10 March 2022  
Ref 20417

**SSD-15882721**  
**PROPOSED MIXED USE DEVELOPMENT**  
**LOT 55 DP 1253217 – DORAN DRIVE PLAZA PRECINCT**  
**VEHICULAR ACCESS, ON-SITE LOADING & WASTE COLLECTION MATTERS**

I refer to your letter dated 14 September 2021 requesting additional information in respect to the abovementioned development proposal (SSD-15882721). The following advice is provided in respect of the matters raised under the ‘*Internal Traffic and circulation comments*’ – *Item 3* and ‘*Asset Management, Traffic and Parks*’ sections of your letter.

PROJECT NO.
 20417

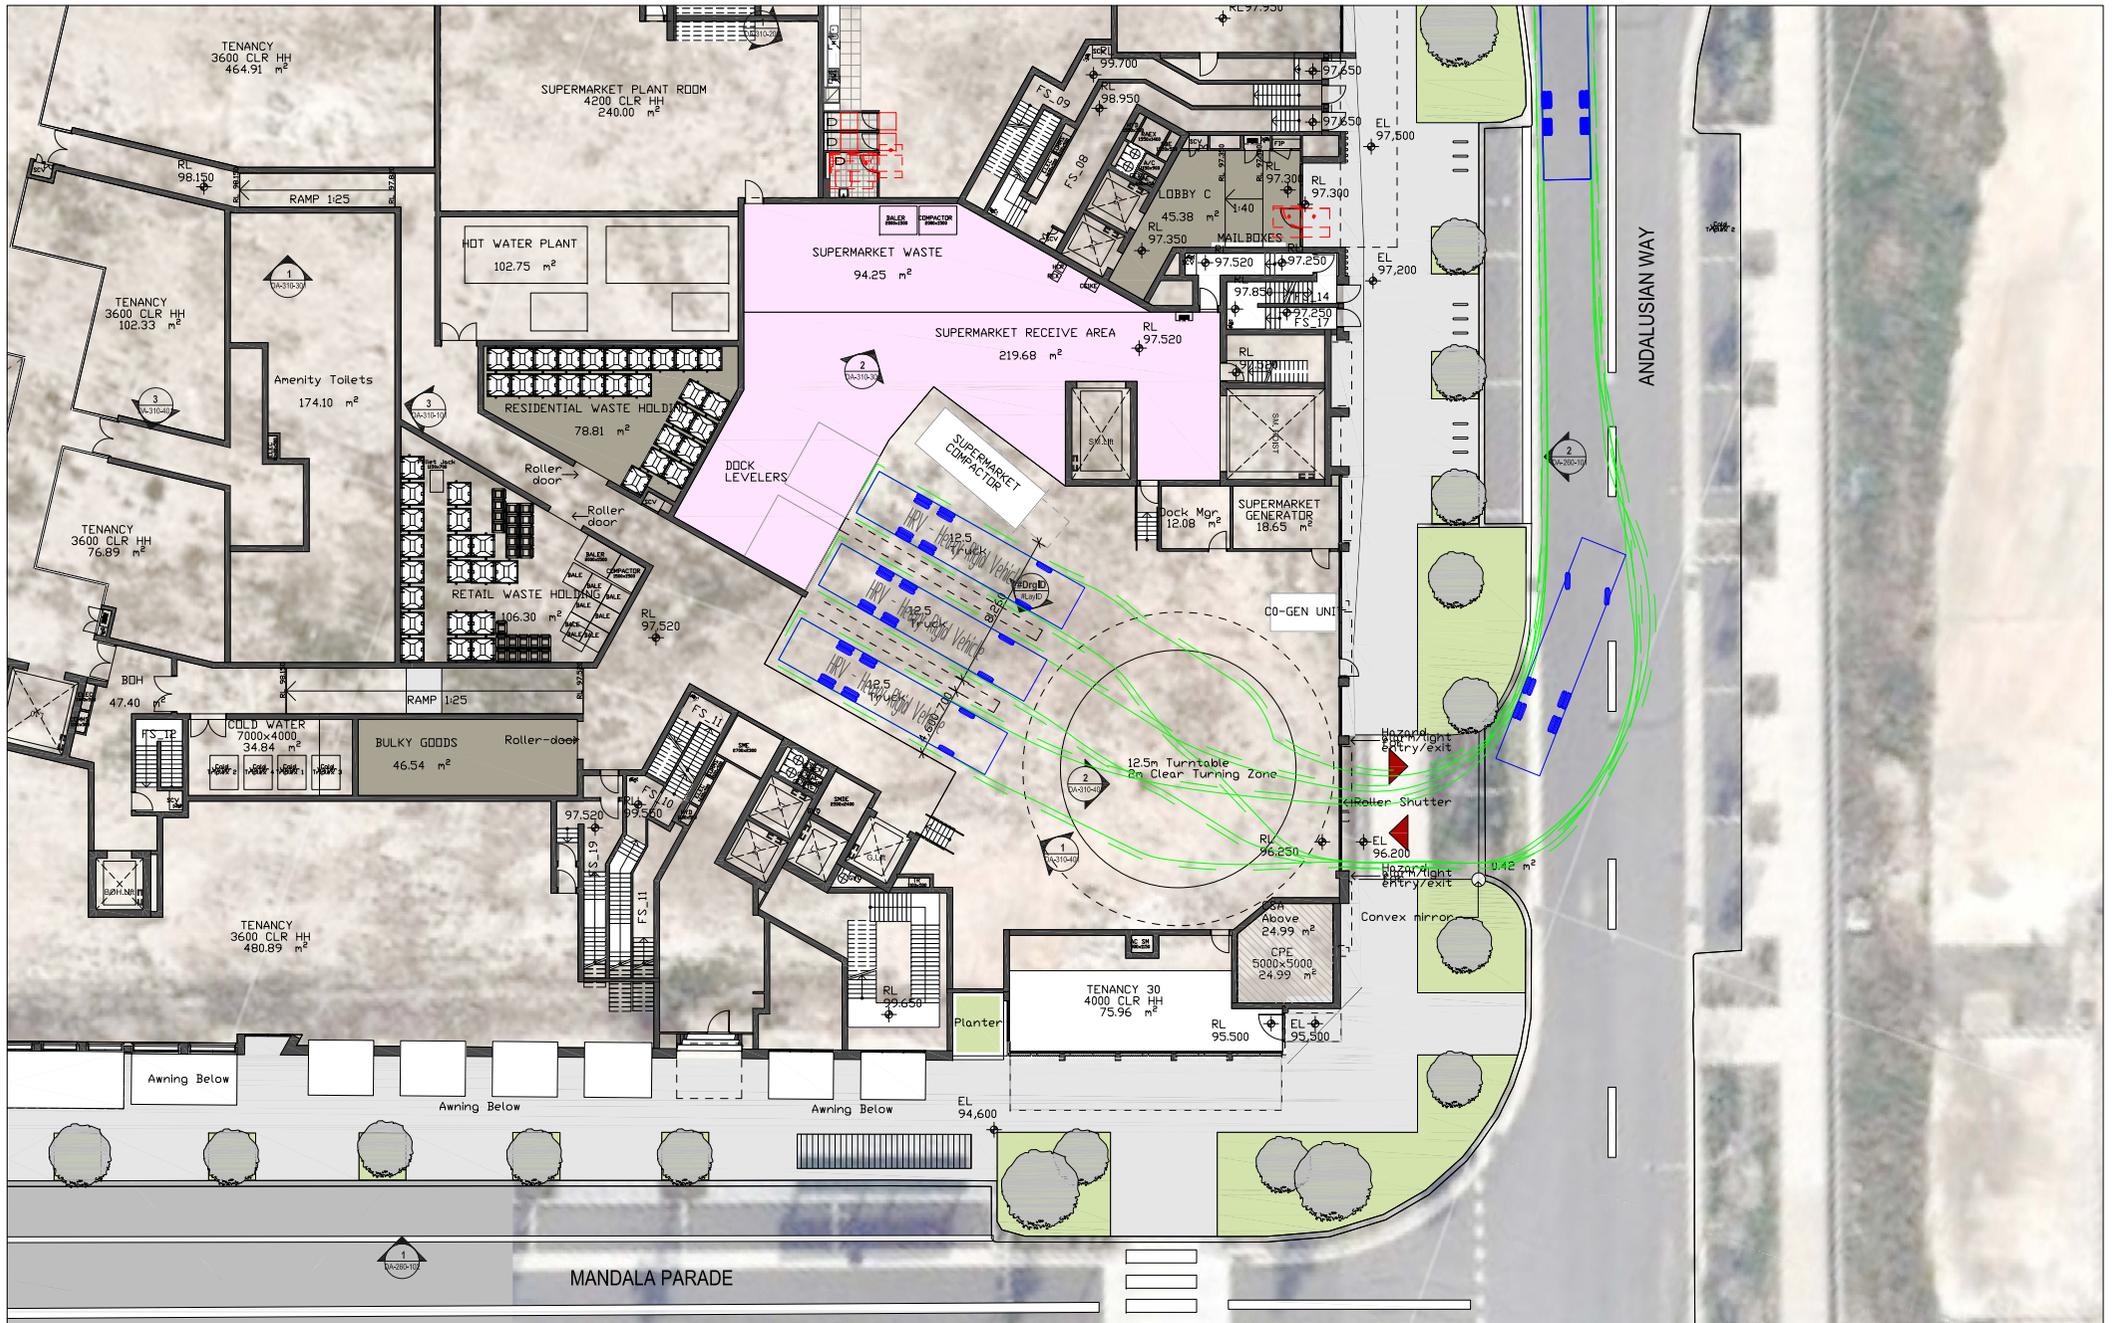
*“Turning path diagrams shall be provided to demonstrate that a 12.5m Heavy Vehicle can turn left from Andalusian Way into the loading dock safely.”*

As requested, we have prepared 12.5m HRV swept turning paths for vehicles accessing the loading dock.

The swept turning path diagrams were prepared using the Autodesk Vehicle Tracking 2022 program in accordance with the requirements of AS2890.2:2018, and confirm that the HRV trucks will be able to enter and exit the site in a forward direction at all times as well as *turn left from Andalusian Way into the loading dock safely*.
